From: Olson, Greg
Sent: Tuesday, January 07, 2014 11:11 AM
To: 'Pena, Jonathan'
Cc: Olson, Greg
Subject: K11-E083 ESC Plan for Townsend Ave

Quick notes on the ESC plan:

EROSION AND SEDIMENT CONTROL PLAN

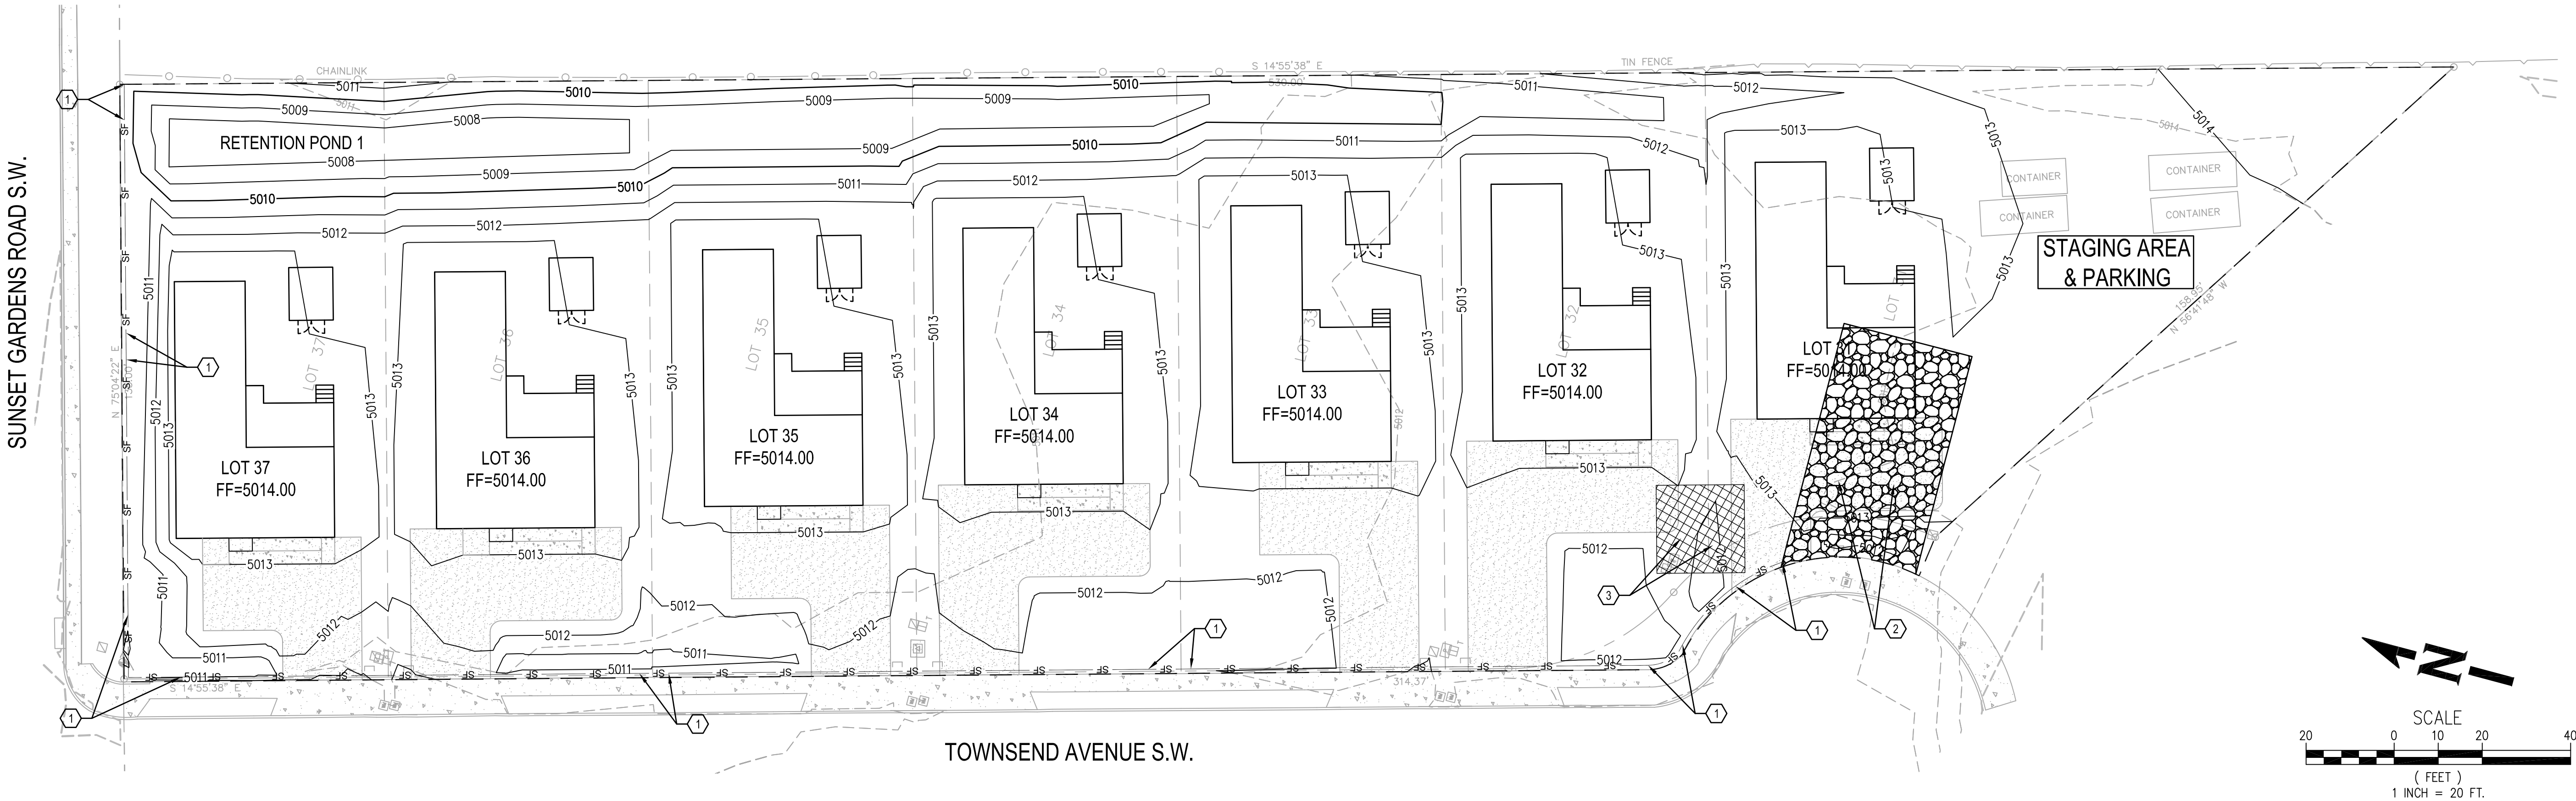
1. The Stabilized Construction Entrance detail text is too small and blurry to read.
2. The Construction Entrance on the plan does not meet the 50' length requirement behind the existing drivepad.
3. The Silt Fence detail does not identify whether the fabric is staked (stake size?) or secured to site fencing (wired?).
4. Clarify whether the Silt Fence Filter Fabric is buried vertically "1'-0" MIN." or does it wrap under the 4" x 4" compacted fill in trench. Line weight in the detail does not clearly show the limits of the fabric.
